Subject: LU/382/21/PL - Refurbish and renew the first and second floors of the existing building to the southern side

The **Arun District Conservation Area Advisory Panel** wish to make the following comments in respect of the above planning application :

Objection

DRAWING TITLE :
PROPOSED ELEVATIONS & SECTIONS

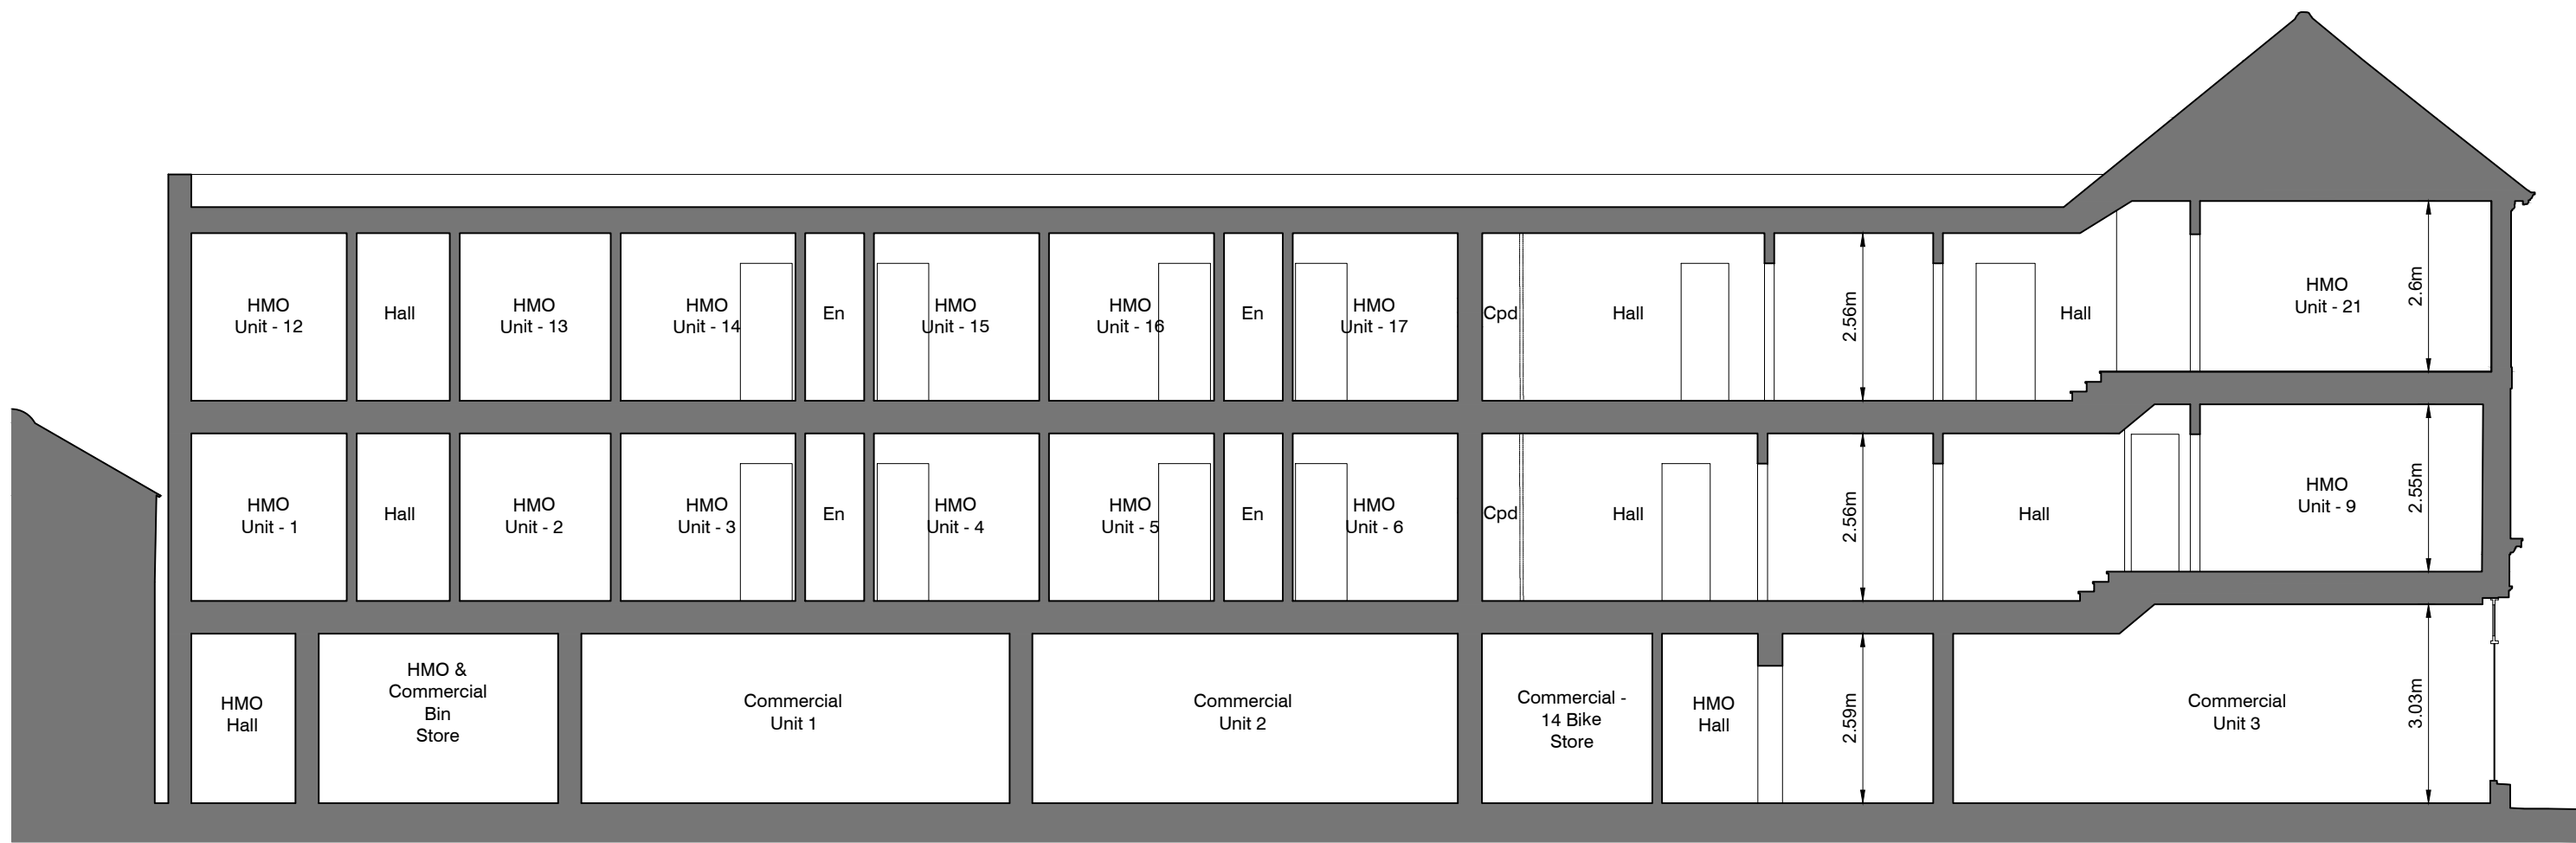
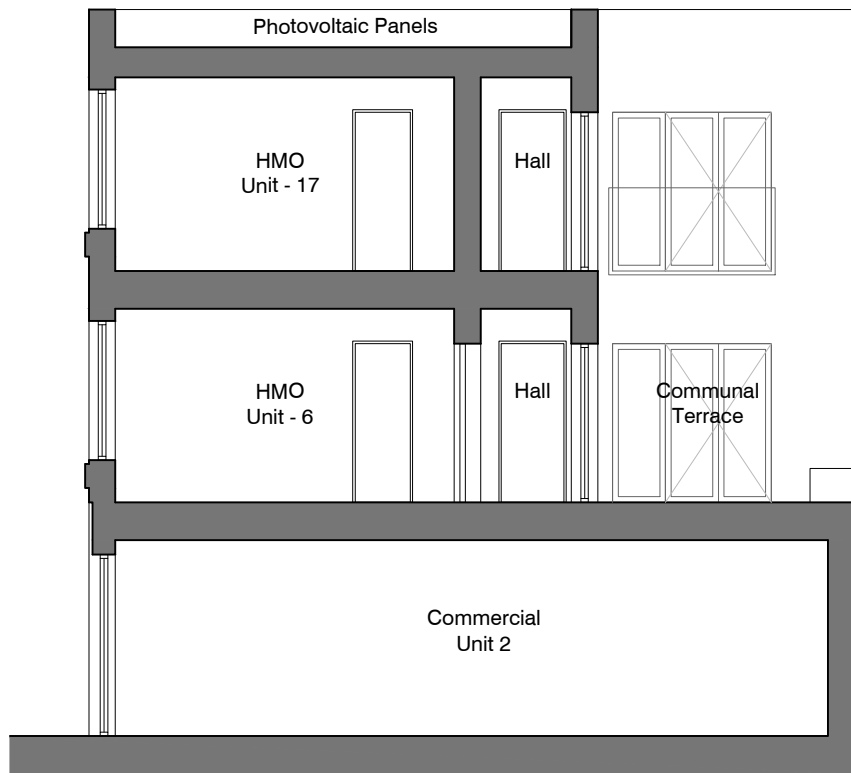
The effective height of the extension from ground level is equivalent to three storeys and is terminated with a flat roof which is not typical of the locality. The height and form of the building structure will appear incongruous, overlarge, and distinctly out of keeping with the two storey, pitched roof form of the buildings opposite and to the north of the application site. It is also clearly overbearing in relation to the adjacent building to the north (2 and 4 East Street).

The junction between the new extension and the existing main building is also unfortunate in that there is the loss of the visual prominence of the latter and the loss of the interesting detailing mentioned above due to the three storey extension.

The small breaks and changes in plane together with the three storey flat roof form of the extension and its repetitive (untypical) fenestration will give rise to a monolithic, overlarge and uninteresting building structure which will not reflect the intricate, varied, and attractive form and detailing of the other buildings in the street scene.
